RE: Transmittal of Comments – Boat Ramp Short Plat (SP-14-00004)

SUBJECT: Boat Ramp Short Plat SP-14-00004

Project: TC-13-00010 Boat Ramp Short Plat SP-14-00004

BOAT RAMP SHORT PLAT  
 PART OF SECTION 30, T. 17 N., R. 23 E., W.M.  
 KITTITAS COUNTY, WASHINGTON

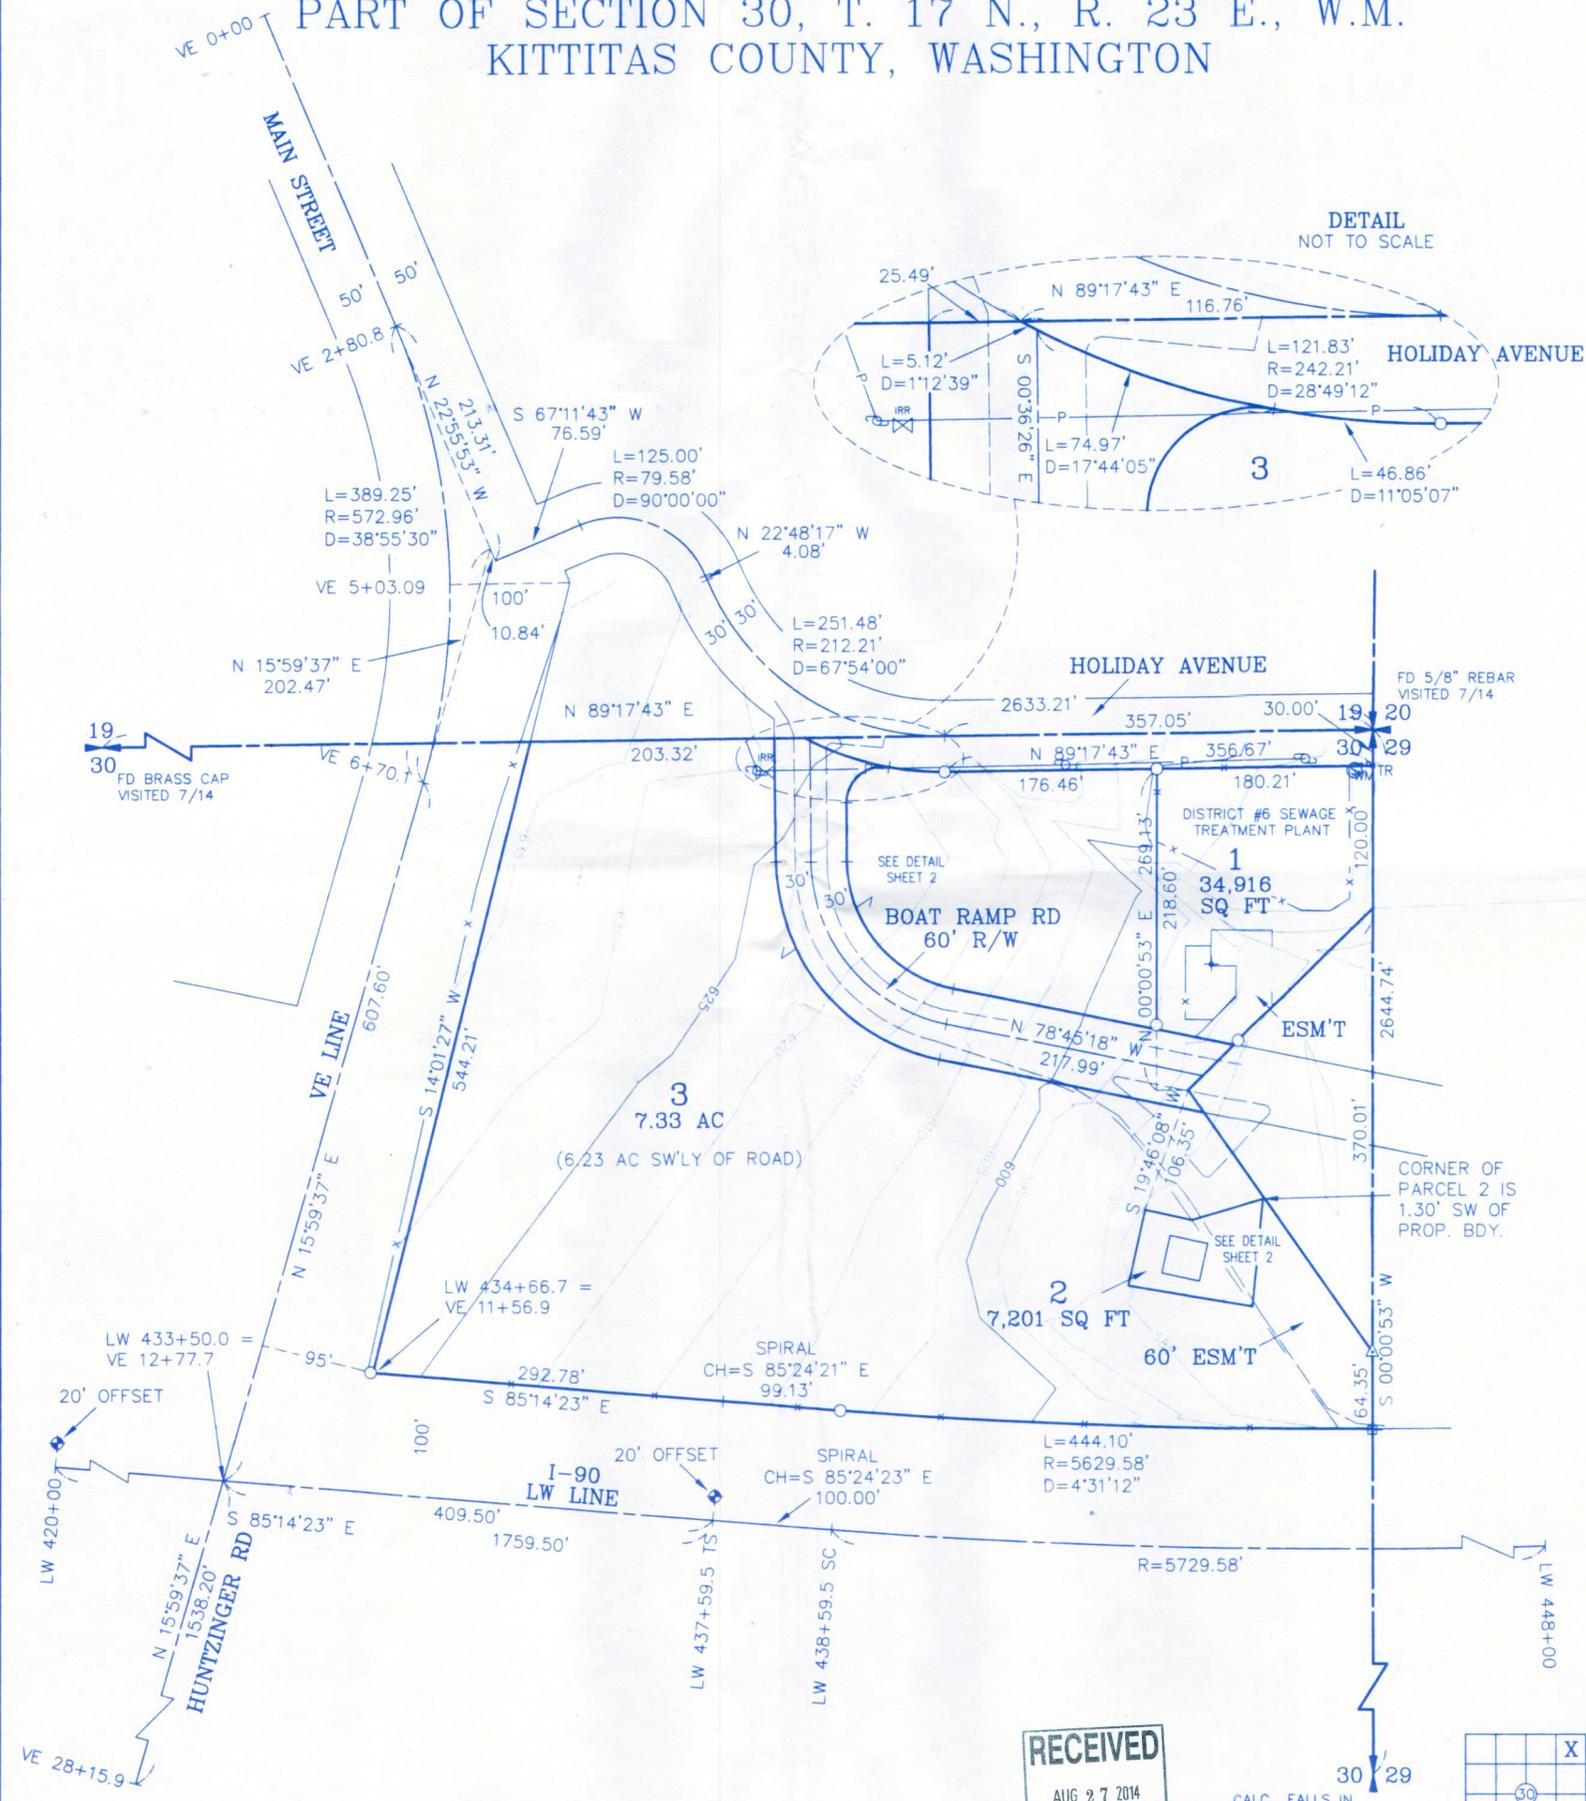
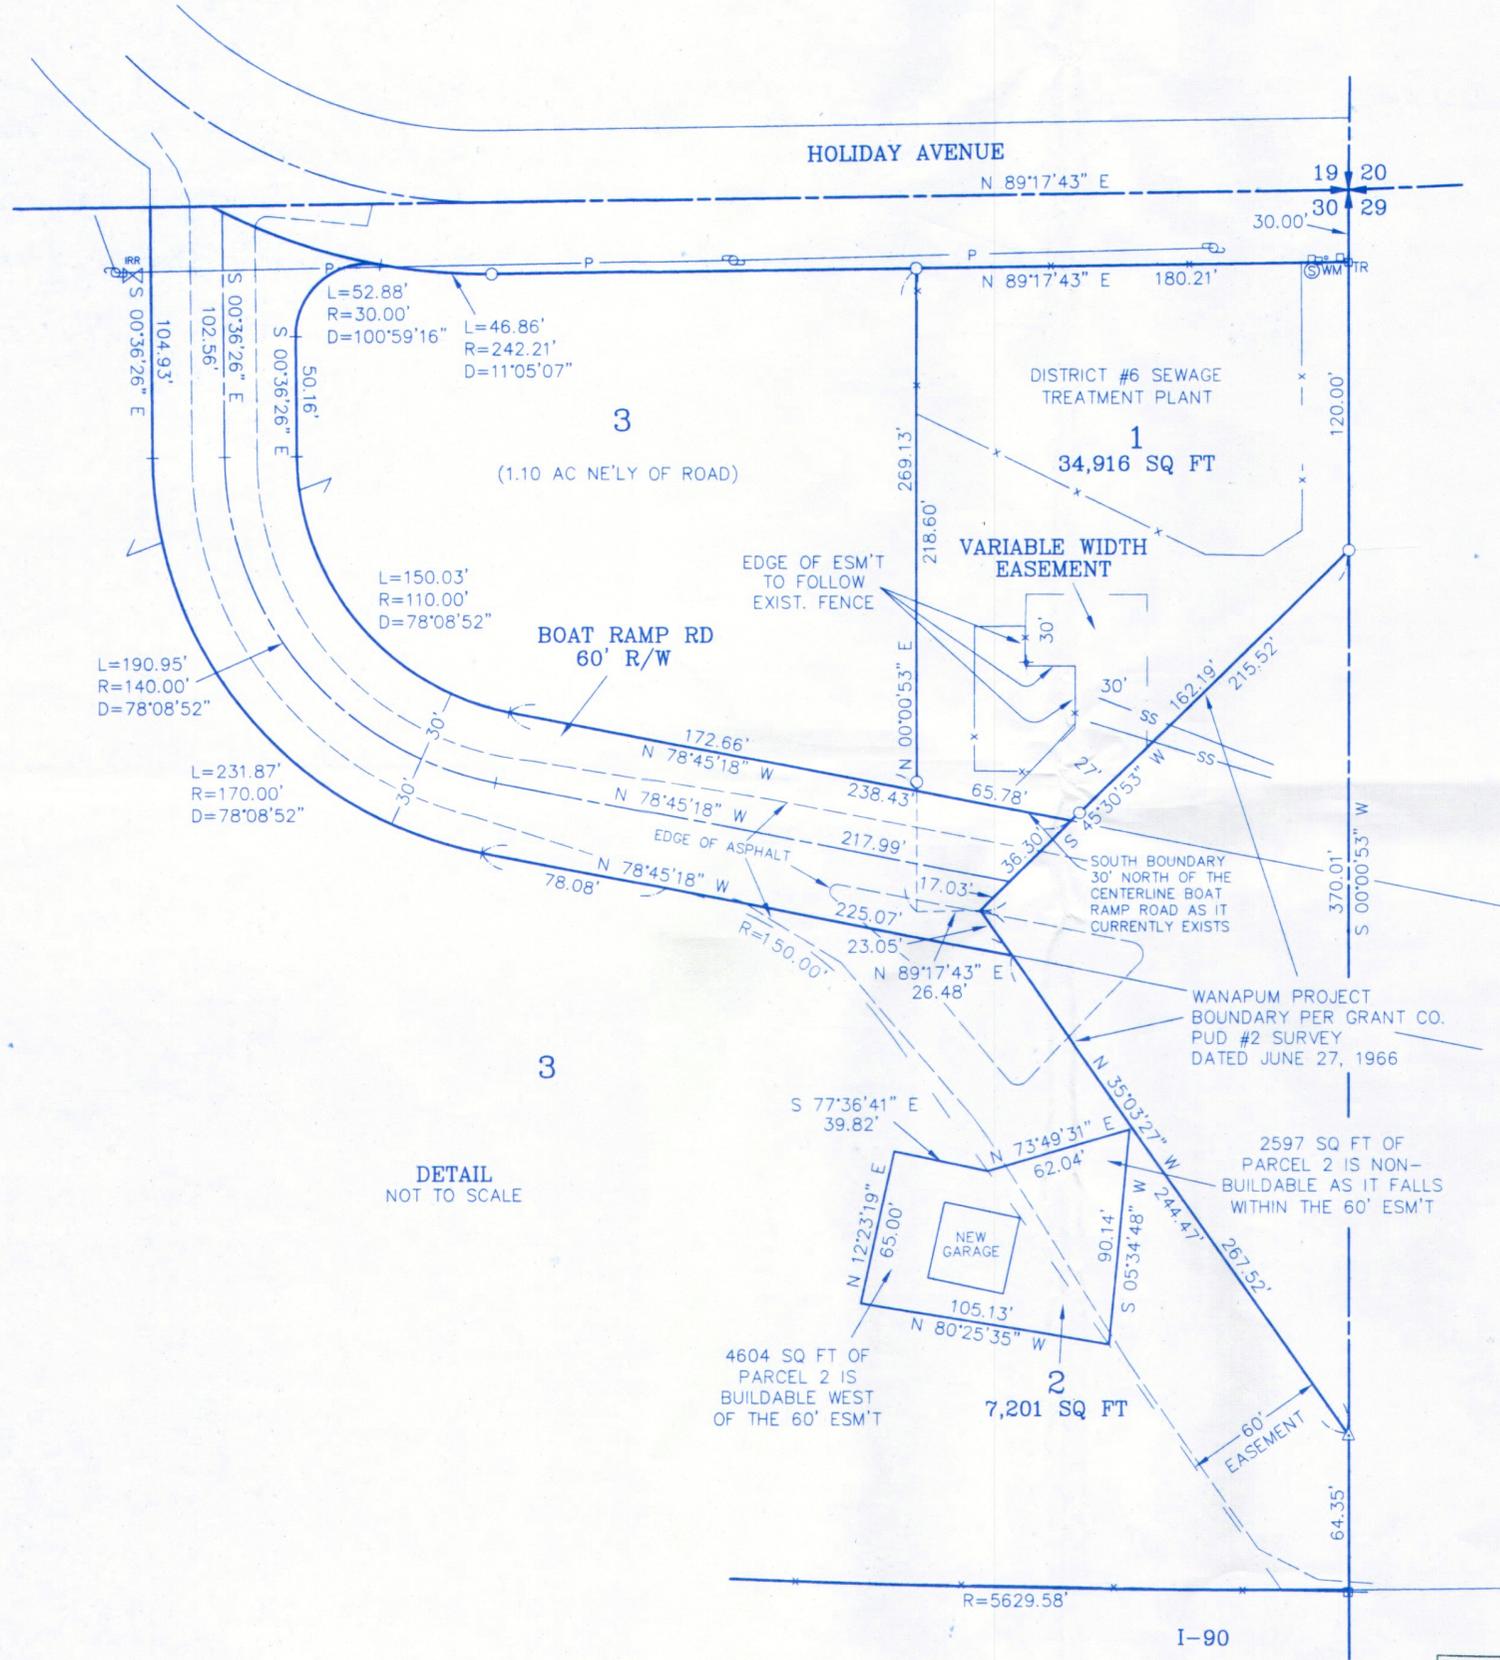
WSDOT finds ownership issues with this proposal. Our records indicate that WSDOT owns a significant portion of this land. From the proposed short plat, it is the majority of lot 3. I have attached the conveyance deed (AFN 280710) and boundary trace of this deed. We have no records indicating other than our ownership. Also attached is the GIS parcel mapping which more or less, is consistent with our records.

I spoke to Chris Cruse yesterday, who referred me to the title report. Within this report, it identifies a number of conveyance deeds after 1960. I guess it is possible that one of these may be a conveyance of property from WSDOT back to the County, but we have no record of this and our right-of-way plan (attached) has no reference to any conveyance back to the County. We note the reference to "4.22 acres of excess r/w" on this plan but have no record of change in ownership.

I checked the certification of the Vantage highway back to the County in 1966, and that certification begins at VE 2+80.8. Meaning, that process did not convey or relinquish ownership of the property in question.

In the absence of a deed or some other instrument indicating otherwise, WSDOT is the owner of the majority of this property in the short plat.
This short plat cannot move forward.

Comments are due next Monday. WSDOT recommends the County either suspend or terminate this proposal. If the County or proponent has records to indicate otherwise, please provide us the appropriate document and we will review accordingly.
